WEST SUSSEX COUNTY COUNCIL CONSULTATION

TO:	Arun District Council FAO: Andrew Wood
FROM:	Highways, WSCC: Tim Townsend
DATE:	25th March 2019
LOCATION:	Former Windroos Nursery, Worthing Road, Littlehampton, BN17 6LY
SUBJECT:	LU/25/19/DOC Approval of details reserved by condition imposed on planning reference LU/229/10 relating to Condition 11 - Vehicle Swept Path, Adoption and CMS.
DATE OF SITE VISIT:	
RECOMMENDATION:	☒ Advice ☐ Objection ☐ Modification ☐ No Objection ☐ More Information ☐ Refusal
S106 CONTRIBUTION TOTAL:	£(N/A for purposes of this application)

This is the second County Highways Authority (CHA) response to the above planning application for approval of details reserved by condition imposed on planning reference LU/229/10 relating to Condition 11 - Vehicle Swept Path, Adoption and Construction Management Statement (CMS). Comments below respond to Drawing No.'s XXX and associated further information provided by the applicant's agents.

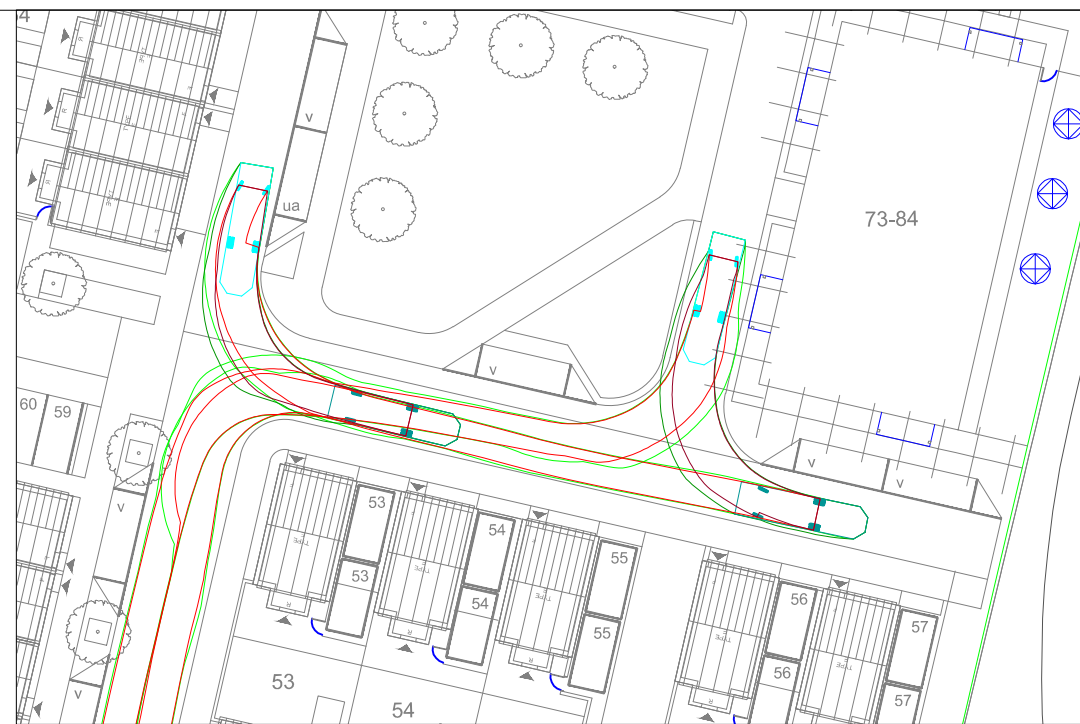
Vehicle swept-path (VSP) – While VSP diagrams have been submitted showing the tracking of both refuse and fire appliance vehicles – both within the layout and through a junction arrangement proposed when the application was originally submitted - the VSP appears on a different version of the layout from that shown on the "S38 General Arrangement" (Drawing No. 063.5001.105 Rev. 'A'). As such, the applicant should confirm the final layout and confirm that the tracking is on the correct drawing. The tracking should also be shown on a drawing showing the proposed alterations to the A259, as proposed by WSCC. Copies of the latter can be obtained on request from the CHA.

It is understood that the developers (under a future separate planning application) intend to submit details for a revised version of the layout. However, in order to satisfy the obligations placed within the original outline planning permission, they are seeking approval of the detail of what was indicatively shown at that stage (so original layout). Although not shown on drawing referenced above (so 063.5001.105 Rev. 'A'), the original tracking was undertaken on an earlier version of the layout now submitted and as such, demonstrated access by both service and fire appliances to within the required travel-distances for each dwelling within the layout. Current drawings are: 063.5001.004 Rev. 'C' (Preliminary S38 Arrangement) and 'D' (Indicative extent of highway adoption) - both produced by Paul Basham Associates.

ADOPTABLE EXTENTS AMENDED	AS	D	21.03.19
ADOPTABLE EXTENTS AMENDED	AS	C	19.03.19
ADOPTABLE EXTENTS AMENDED	MS	B	28.03.17
UPDATED LAYOUT AND EXTENTS	BH	A	09.12.16
PRELIMINARY ISSUE	CL	P1	20.08.15

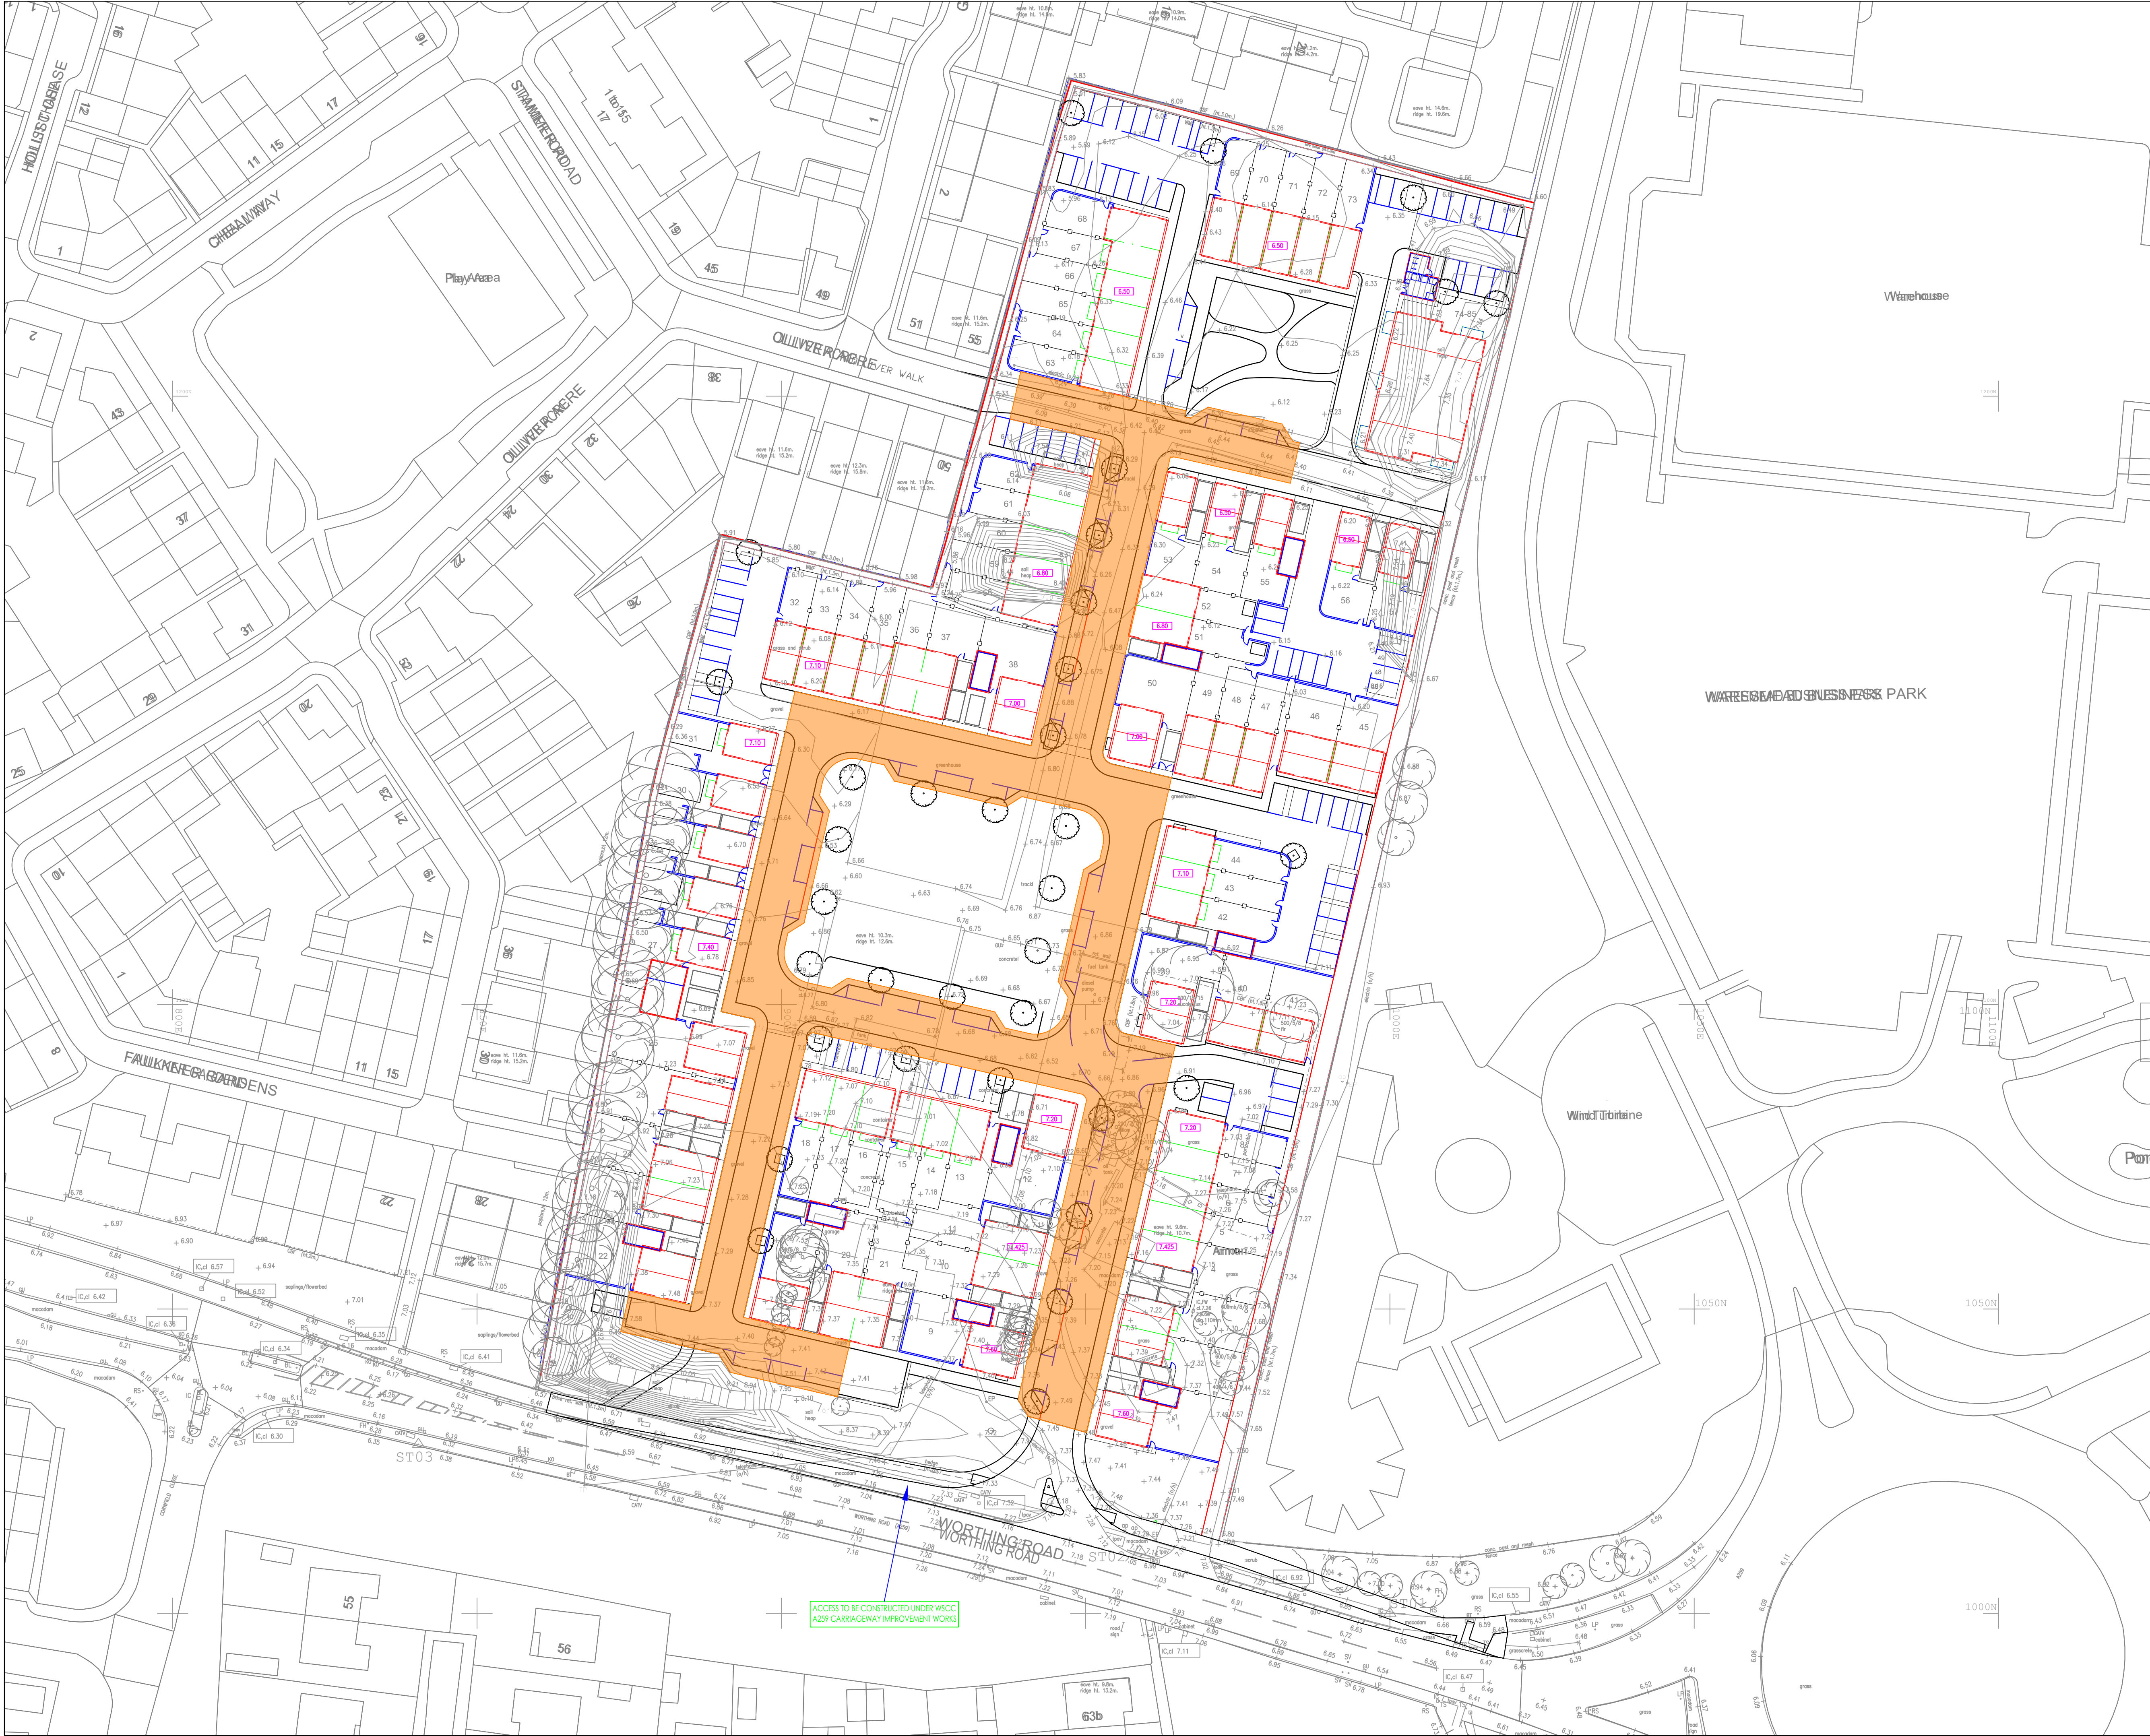
Adoption – Like the comments made above, the applicant should confirm what plan is the correct one showing extent of proposed road adoption. When received, the CHA

will provide further comments. Likewise, comments about the materials proposed will also be made once the correct plan is provided. Street lighting specification does not appear to be available at the time of writing. This too should be submitted. Also see comments under 'other matters' found below.

This is now shown on drawing's 063.5001.004 Rev. 'C' (Preliminary S38 Arrangement) and 'D' (Indicative extent of highway adoption) - both produced by Paul Basham Associates. Both are considered suitable from the CHA's point of view for this DOC application. Material specification, drainage, landscaping and street lighting assessment will be done as part of the S38 checking process post-planning. A decision as to whether the path in the bottom south-western corner of the layout leading from the development to the A259 would be eligible for adoption will be made at the S38 stage.
